**KIRKLEES METROPOLITAN COUNCIL
INVESTMENT & REGENERATION SERVICE**

**DELEGATED DECISION TO DETERMINE APPLICATIONS FOR
NON-MATERIAL AMENDMENTS**

Reference No: **2023/NM/91453/E**

Site Address: 48, Woodburn Avenue, Earlsheaton, Dewsbury, WF12
8LJ

DRAWING N°:
272-01-03A

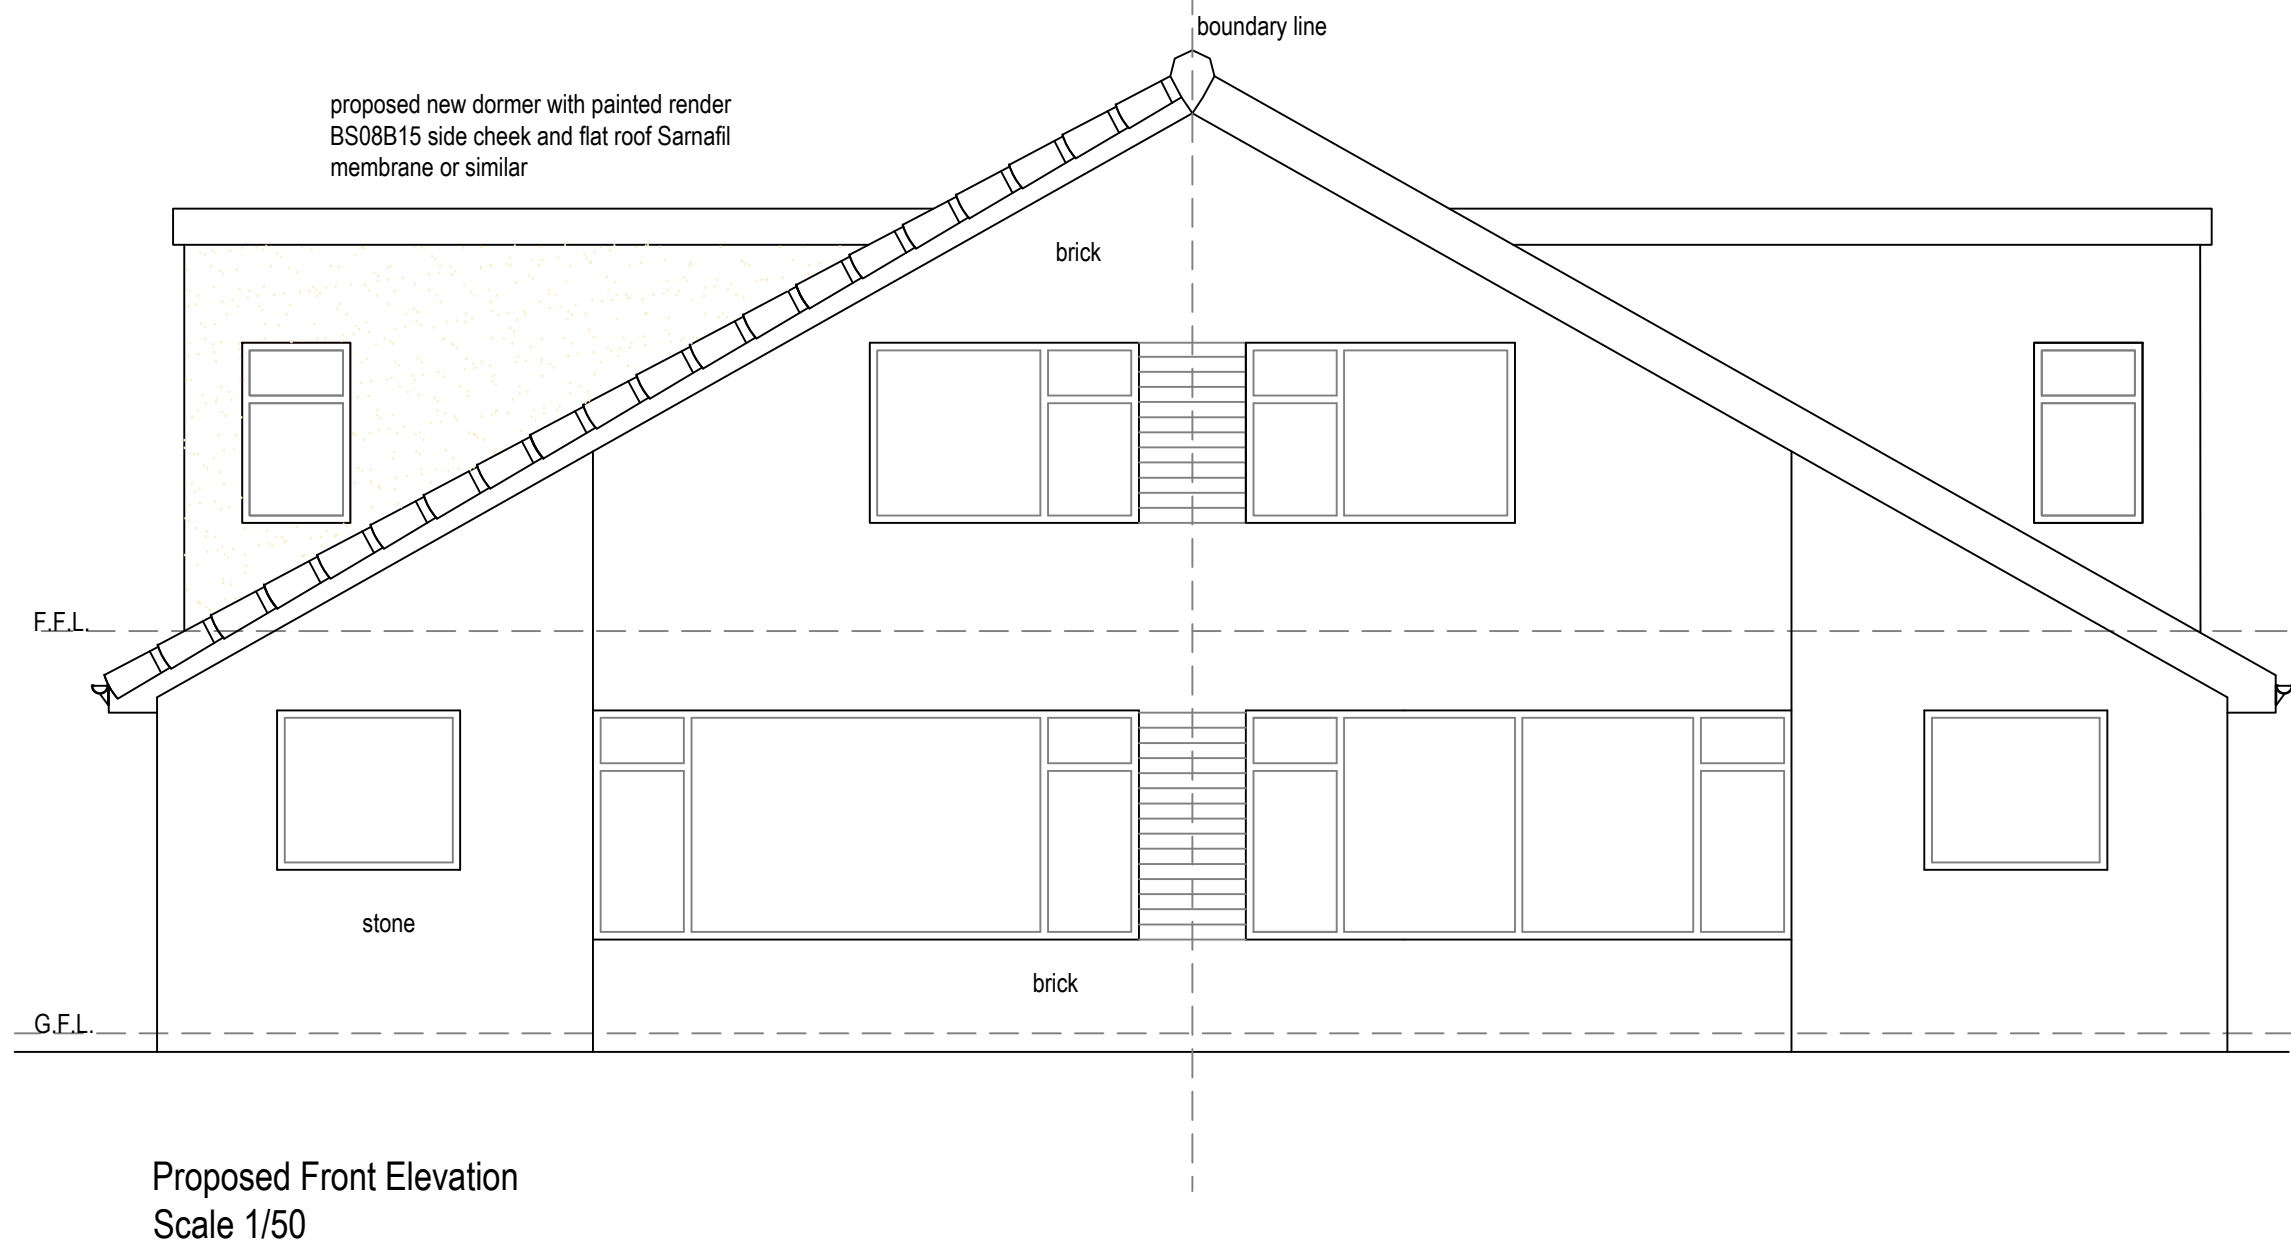
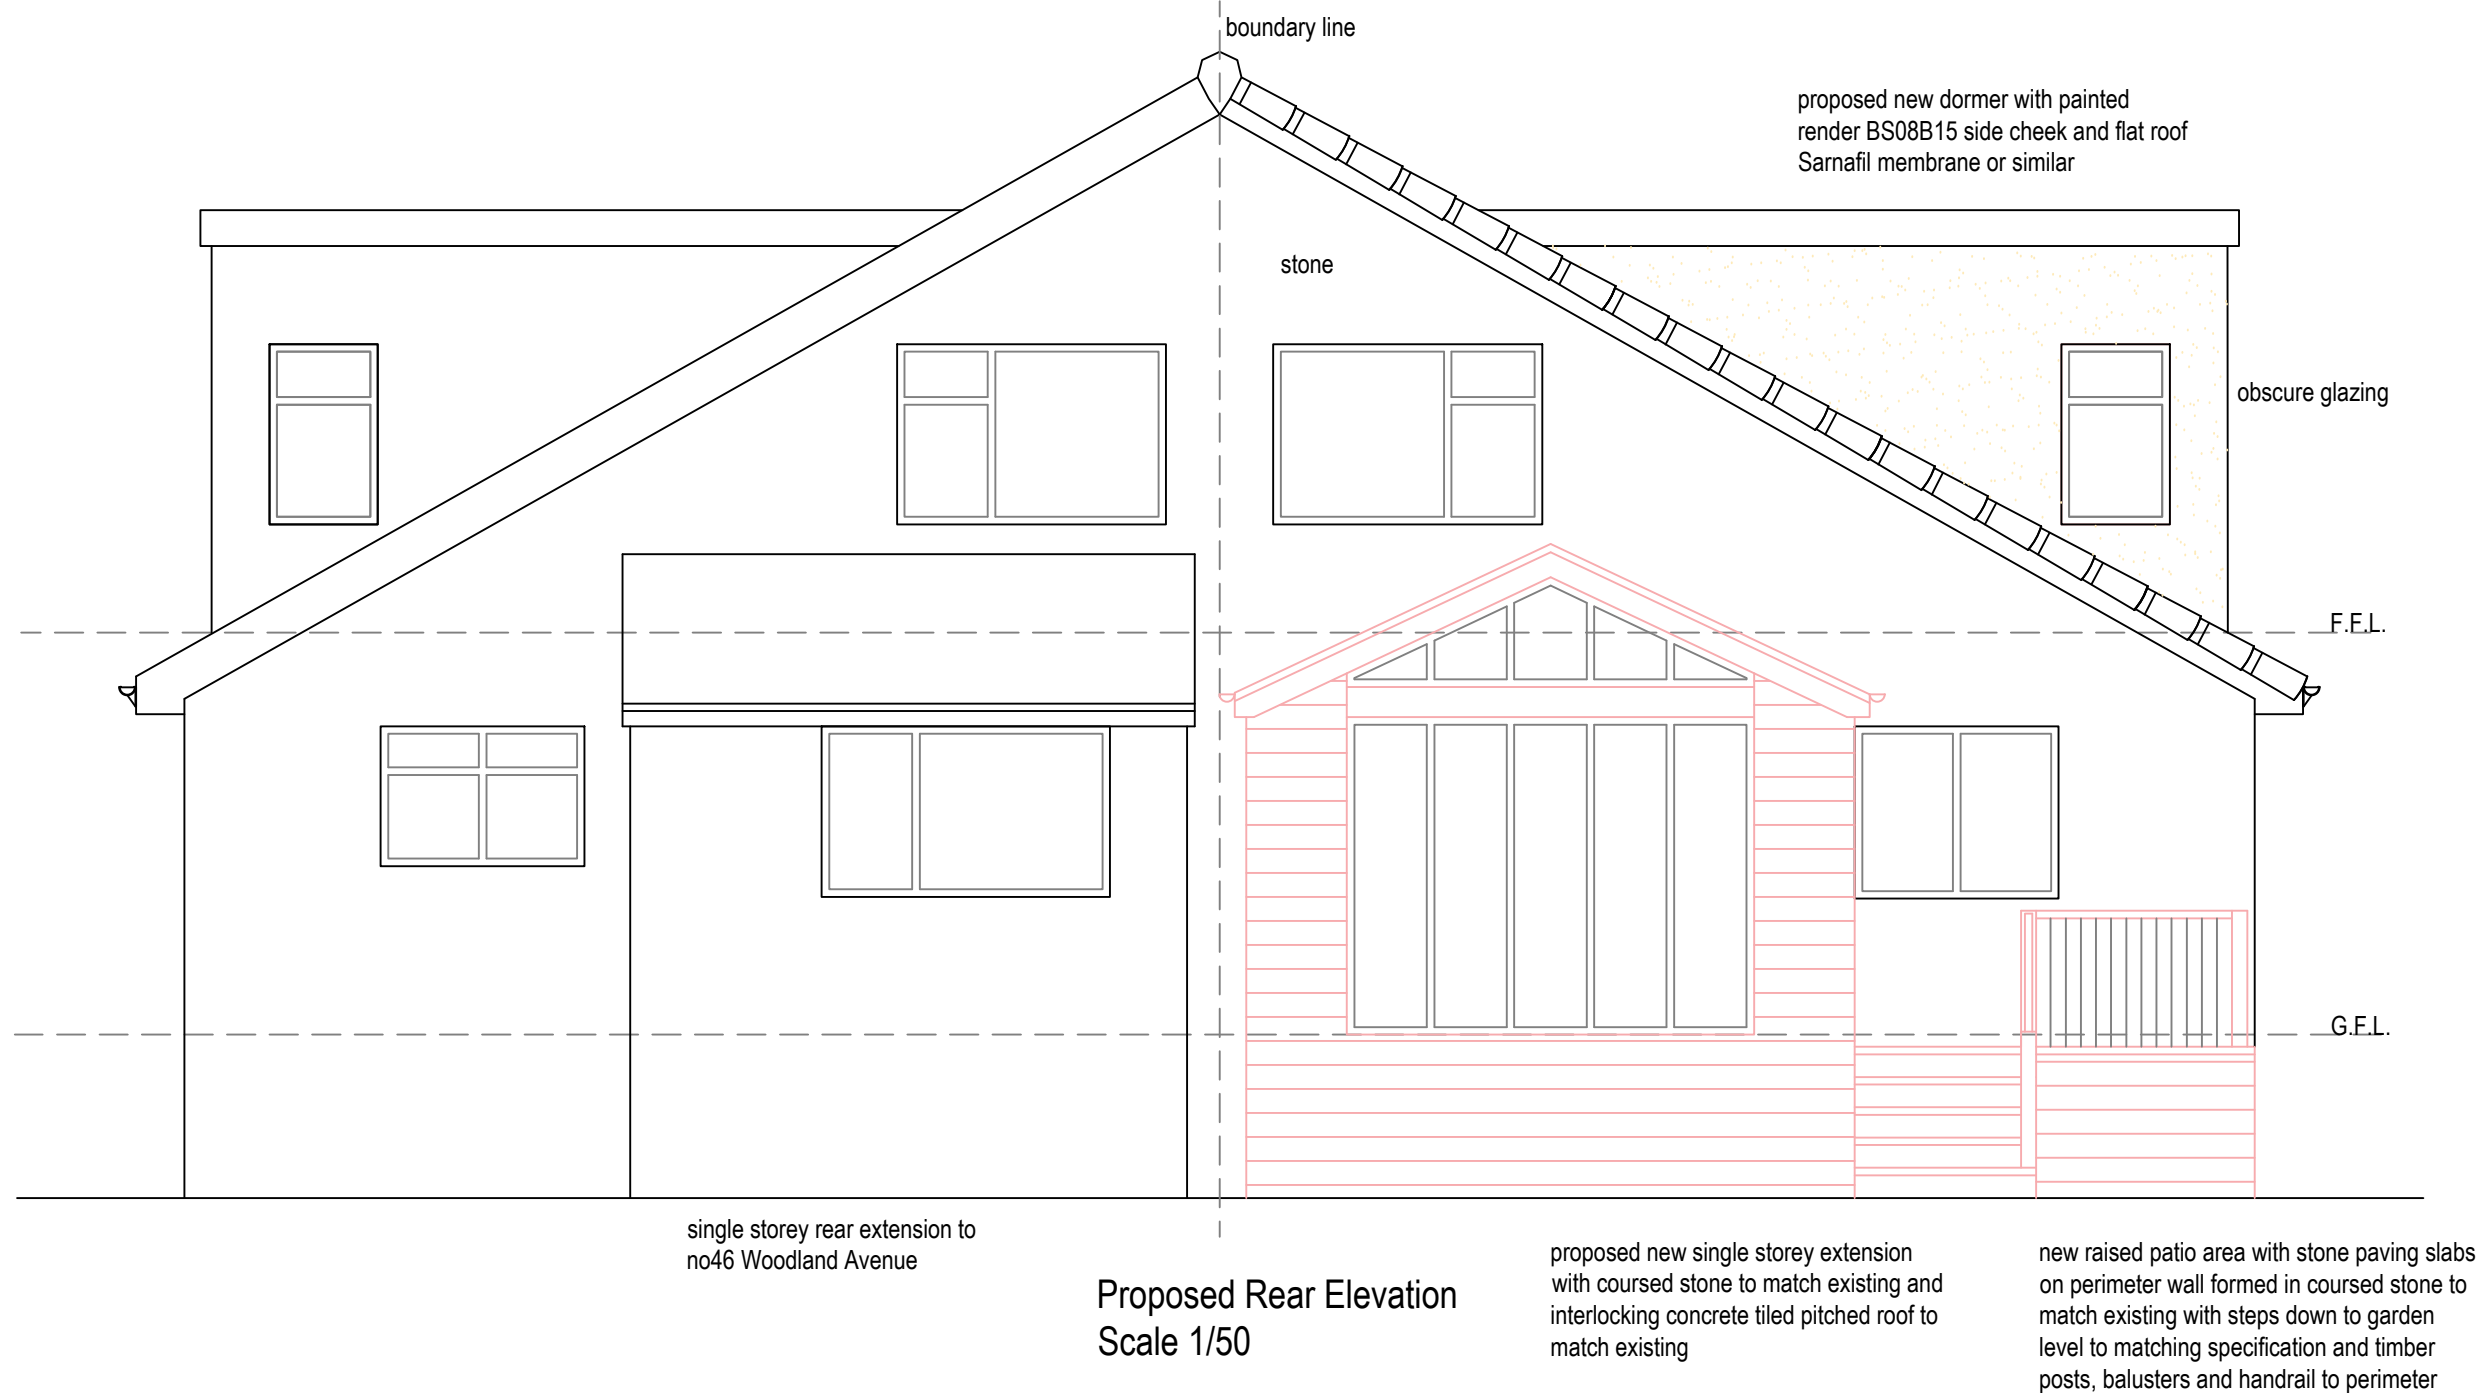
2. *Would the change result in a detrimental impact either visually or in terms of living conditions?* The proposal would amend the materials of the previously approved dormer to feature a rendered finish. There is not currently any render within the street scene and it is considered that the proposal would introduce a new material into the street scene. Therefore, it is considered that the proposal would result in detrimental impact visually.

To conclude, the amendment shown on the submitted drawing 272-01-03A to amend the proposed materials of the previously approved dormer is not

considered to be acceptable and cannot be regarded as a non-material amendment to the previous approval 2022/90937.
